Application Ref: H16-0515-25

Proposal: **Residential development of 76 dwellings and associated infrastructure**

Location: **Land at Horseshoe Road, Spalding, PE11 3JB**

Notice is hereby given that the County Council as Local Highway and Lead Local Flood Authority:

Horseshoe Road, Spalding: Overall Masterplan. LS01 (1:500 @A1)

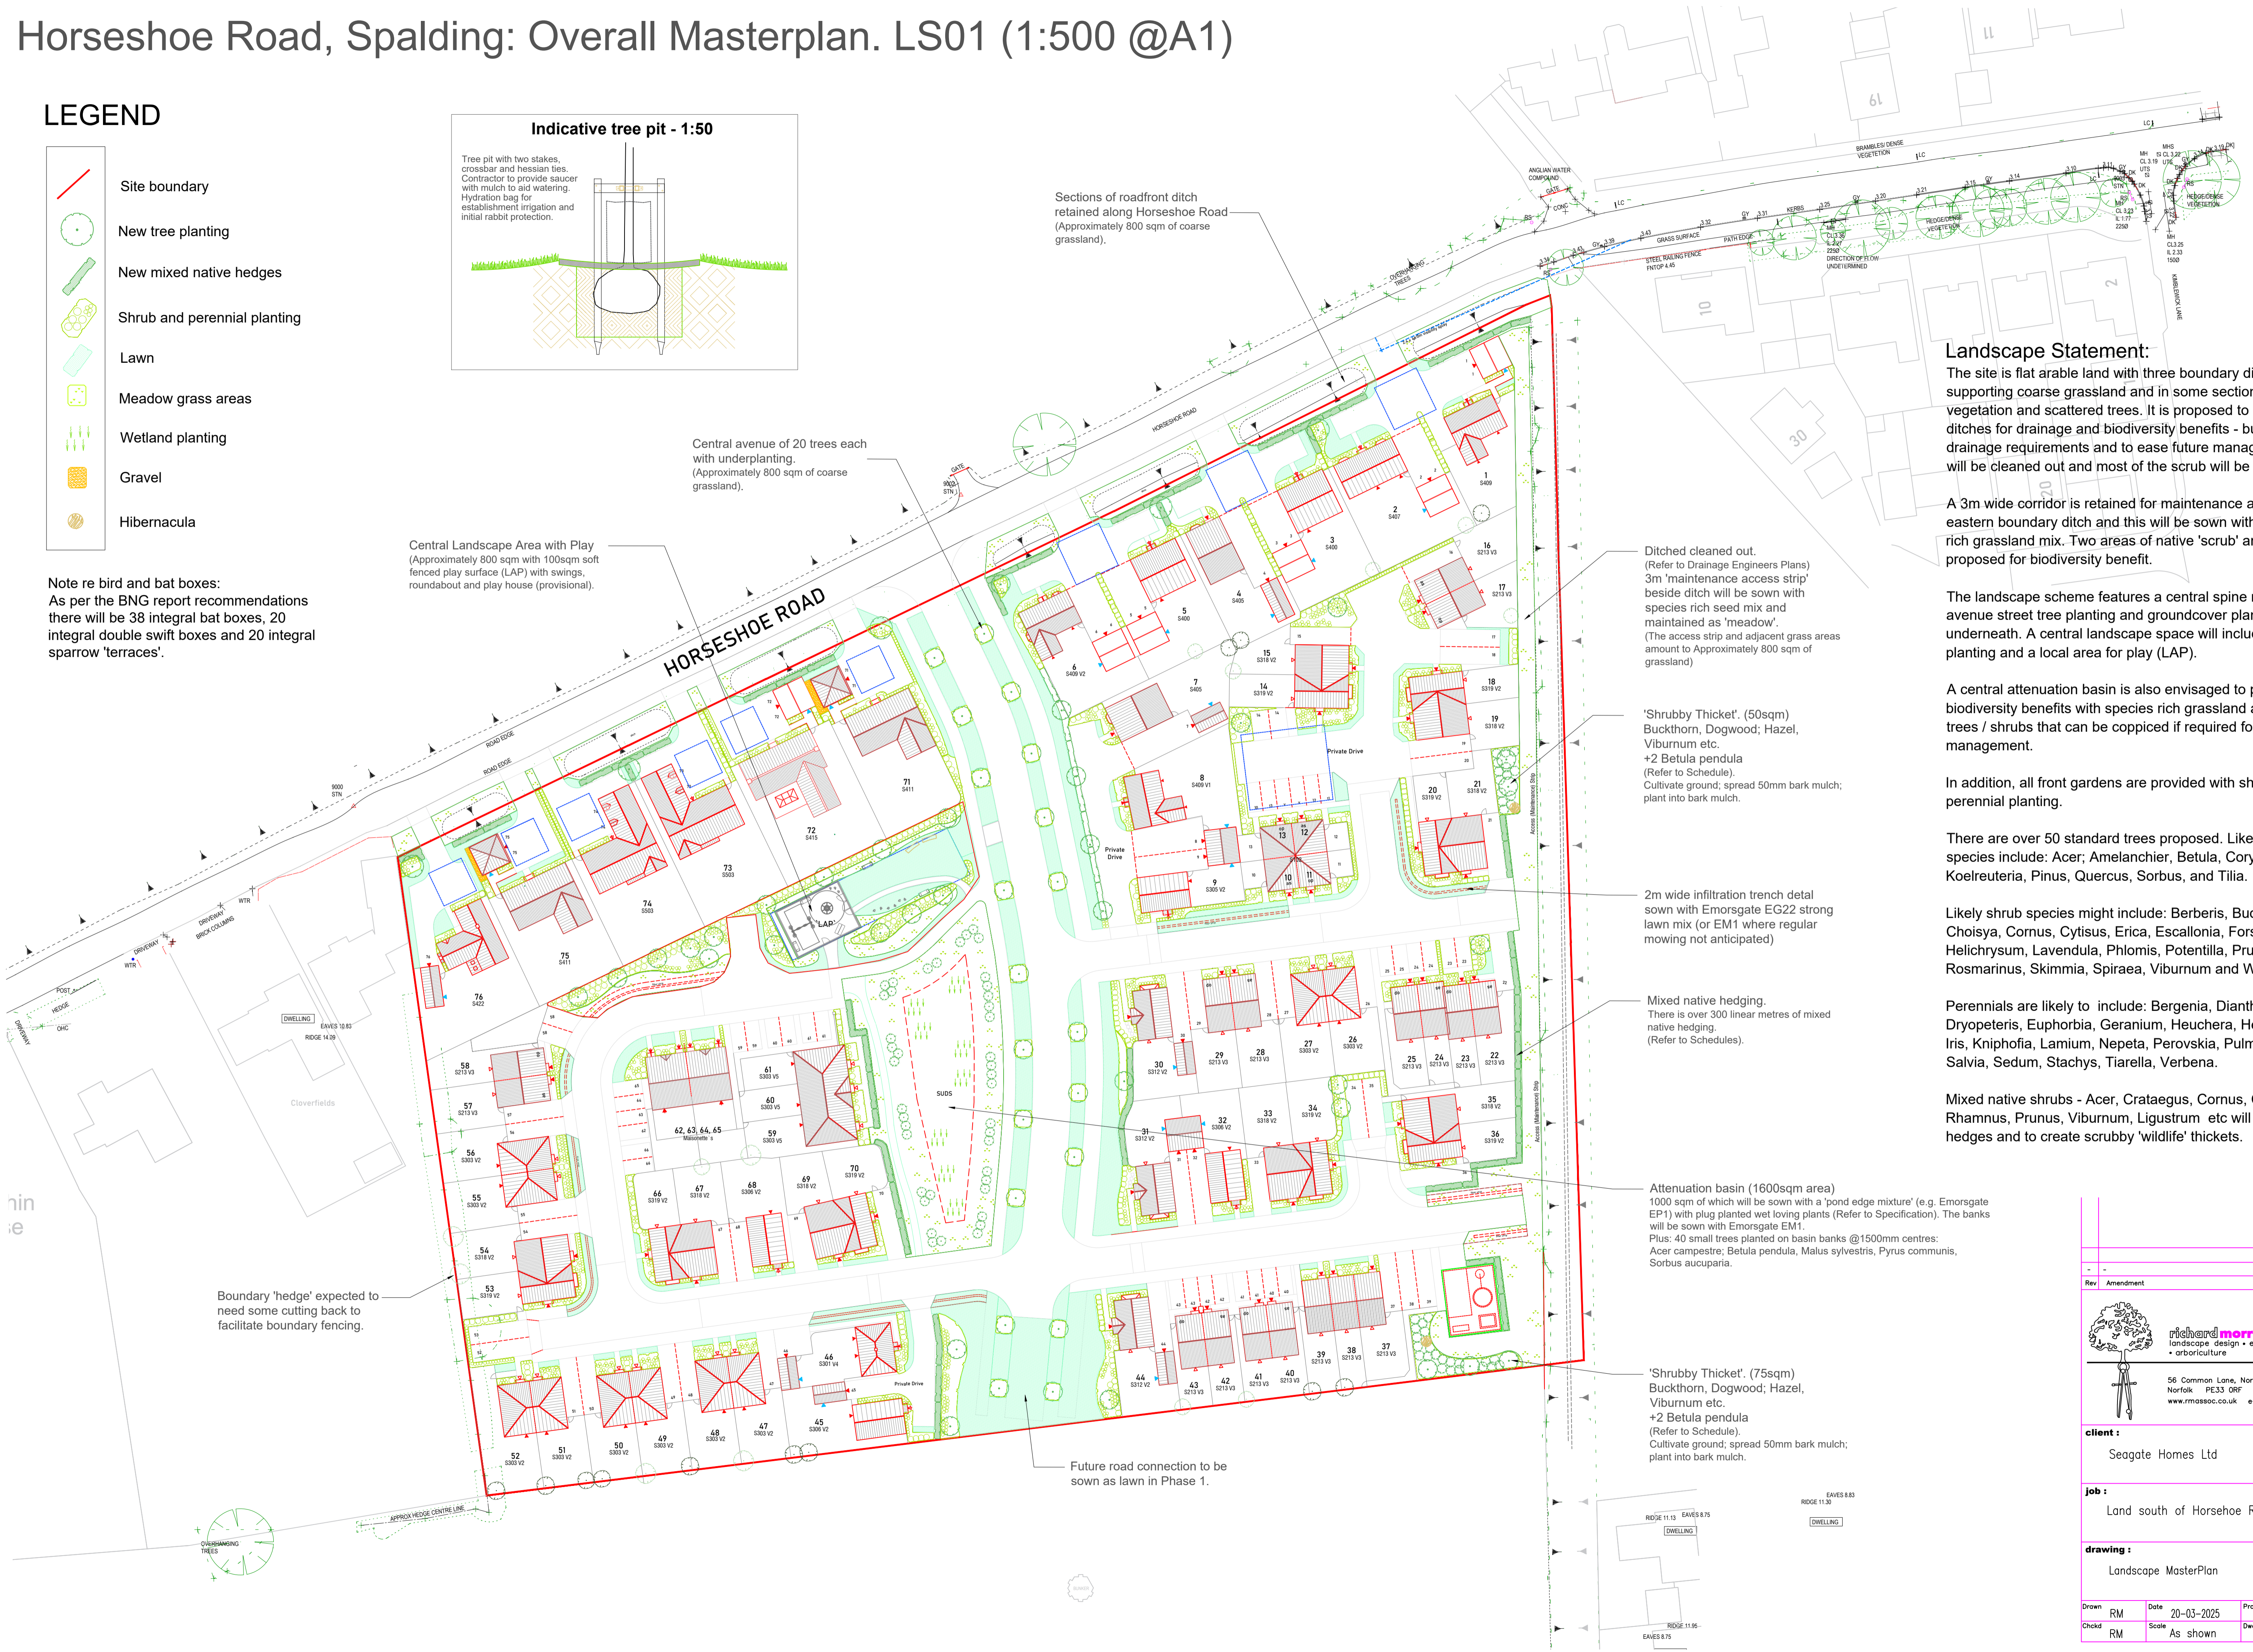
- Cycle storage to be provided for every unit that does not have a garage.
- A 2m footway is proposed along the site frontage on Horseshoe Road. A 2m footway will not fit in on the bend where it meets the existing footway, the road will need to be realigned to achieve the 2m and this will be done under a Section 278 Agreement. This will also involve the removal of a highway tree – a condition will be applied to any planning consent that a replacement highway tree is planted.
- It has been agreed that the Developer will undertake a Speed survey whilst the planning application is live so we can ascertain whether the speed limit will be reduced to a 30 or 40 limit.
- Edge Lanes are to be incorporated into the design to restrict the number of turning heads and improve connectivity.
- Carriageways should go up to the site boundaries so as we do not have a ransom strip issue in the future.

- The traffic calming measures should only be a change in surface not raised.
- The widths of the footways and carriageways should be detailed – it is not clear why the two footways coming into the site are different widths.
- Refuse collection points to be detailed for private drives.
- Visibility at the main access to be detailed in accordance with Manual for Streets.
- Linear parking to be broken up with low level planting.
- Parking for plots 39 & 38, 66 and the maisonettes will not work – residents will park on the road for convenience.
- The large footway expanse at the junction is unnecessary – it should be reduced and street trees incorporated.
